Engineers Comments Regarding Surface Water Drainage

Application Reference:	CM/19/26/PL	Reviewer Reference:	ADC/EXT5/AF
Planning Officer:	Kathryn Welch	Date of Review:	29/09/2026
Site Name:	Baird Business Park Grevatt's Lane Littlehampton BN17 5RE		
Application Description:	Erection of replacement commercial building, parking and other associated infrastructure, including new attenuation pond. This application is in CIL Zone 5 (Zero Rated) as other development.		
Assessment Number:	3

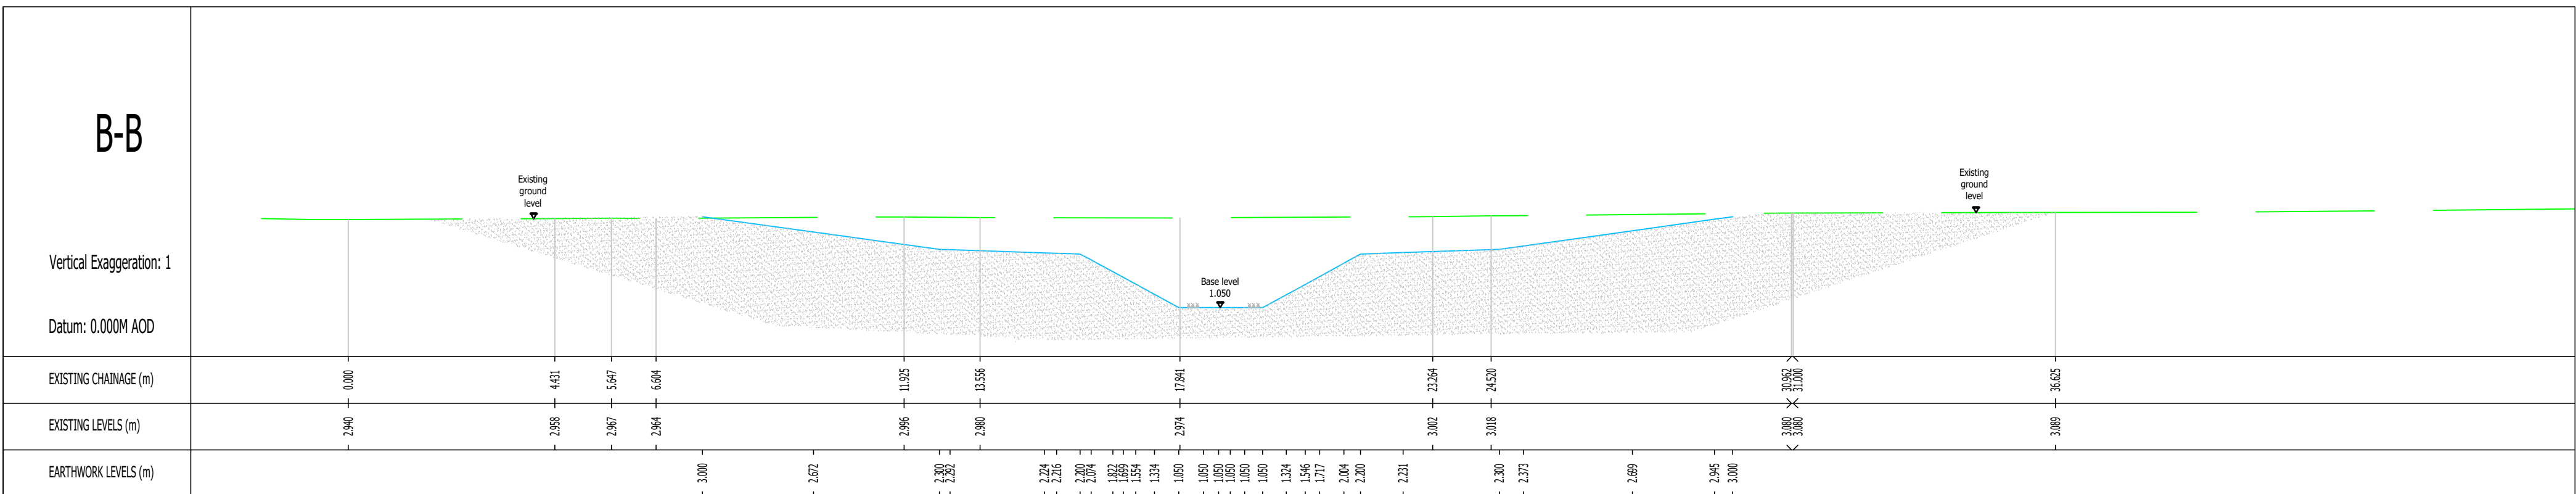
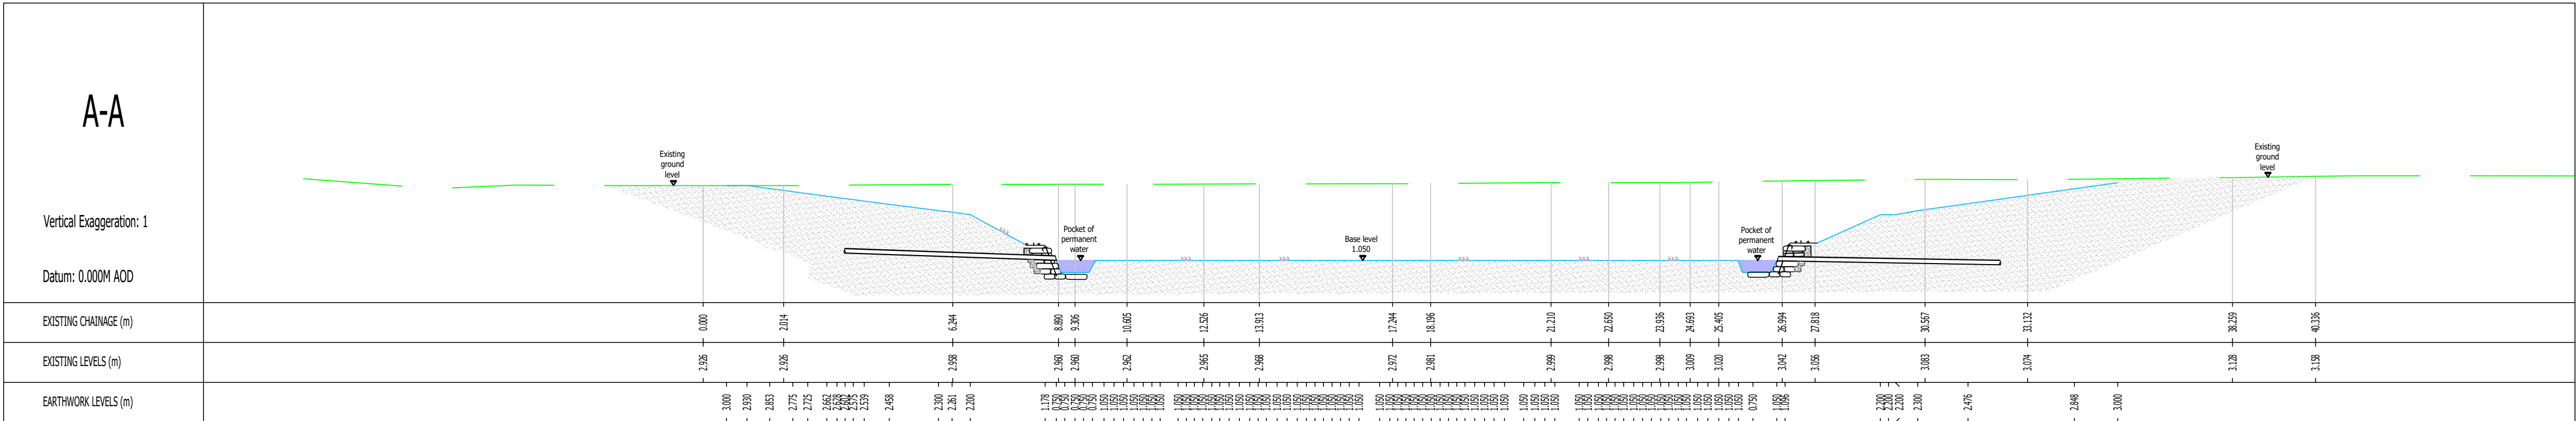
- 3.3. The proposed basin is in a location of existing surface water flood risk. The fluvial flood risk is low in the defended model for the present day. The with climate change fluvial only risk outline is not shown and may or may not affect the basin location.

- 3.4. An assessment of the with climate change surface water flood risk is included and the basin is designed to have a lip at top of bank to keep surface water out of the drainage system.

- 3.5. The displaced pluvial flood water is not quantified / modelled and whilst there is indication in the form of an existing culvert that the true extent of flood risk may be reduced from the national mapping, it is not evidenced. The potential volume of displaced water based upon the national depth mapping for the with climate change scenario should be assessed and mitigated. This analysis can also assist in confirming the basin would not receive flood water over the banks. The Arun DC guidance exceptions are noted in the report which states that 'where an area of surface water flood risk can be evidenced to only receive flow from within the site boundaries' SuDS are permitted in the flood risk area. The catchment of this surface water flood risk could be defined based upon topography to check whether this applies to the basin. Consideration could also be given to relocating the basin outside of the flood risk area.

Project	Baird's Business Park, Littlehampton
Drawing	Tree Protection Plan
Date	01.06.26
Ref	26-2105-TPP
Drawn	NT
Checked	DR
Client	Savills
Scale	1:200@A2

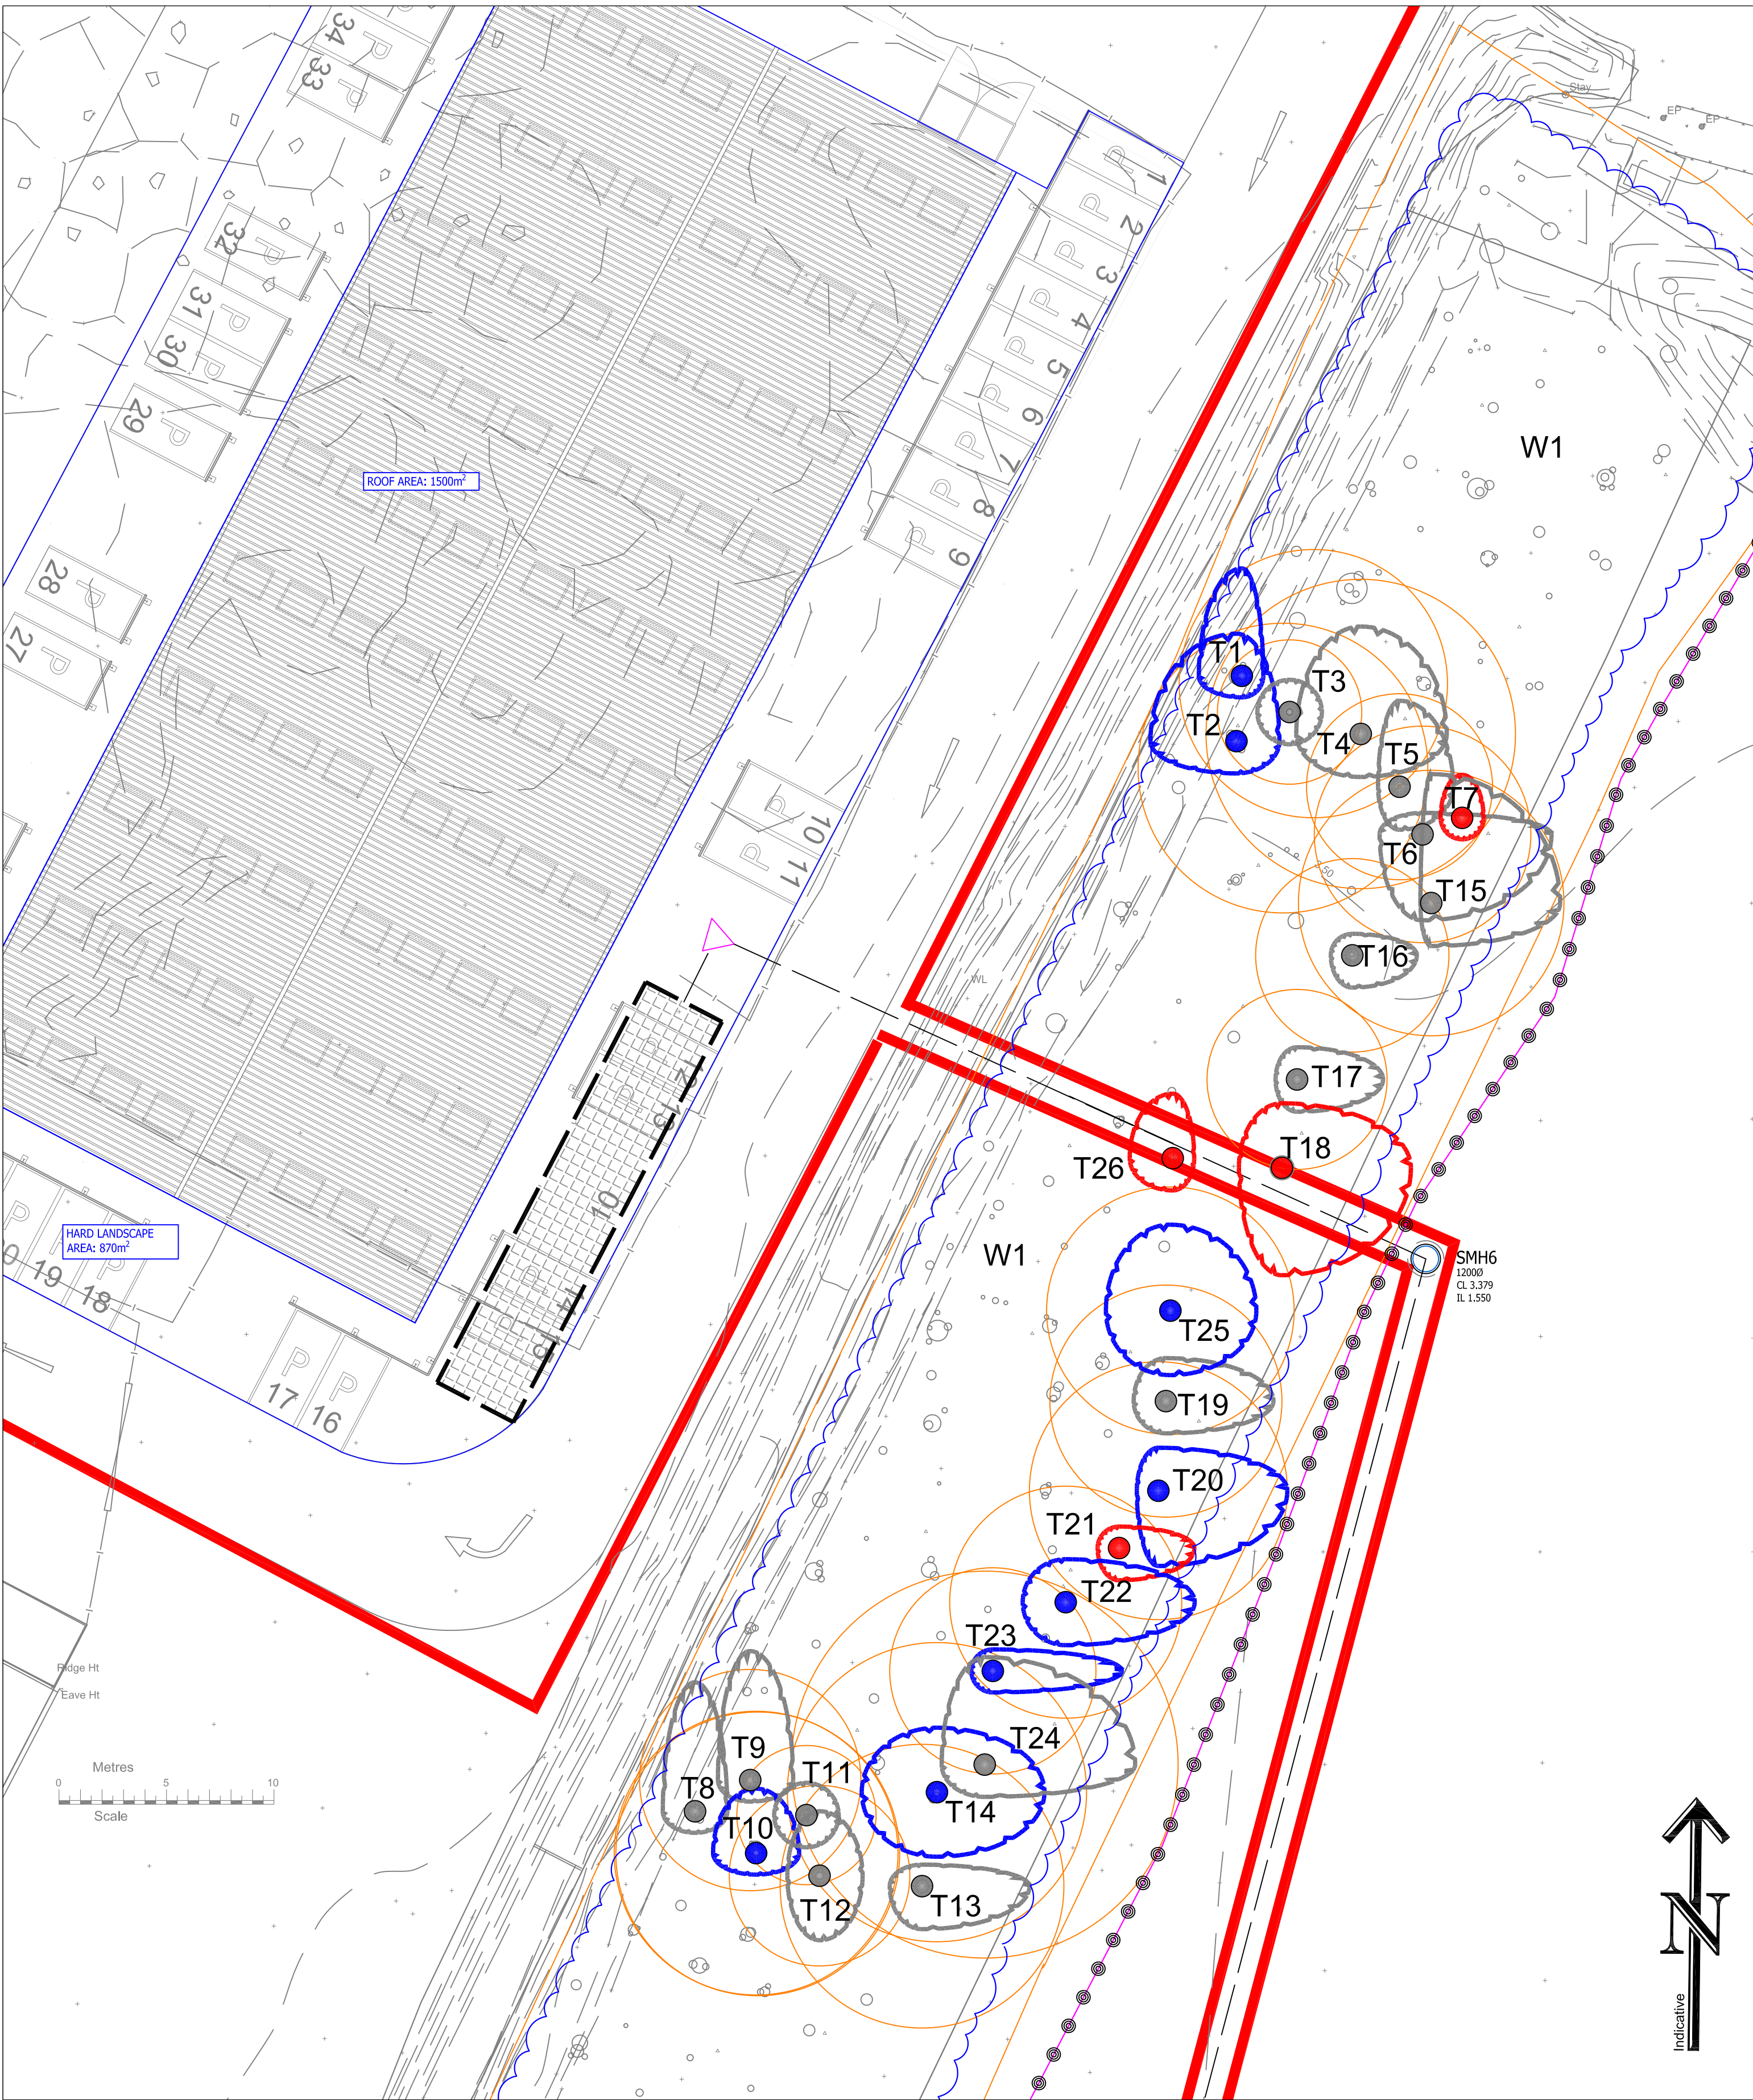
- 1.5. Note – two trees are shown to be removed to facilitate the drainage route to the outfall and the tree Officer should be consulted.
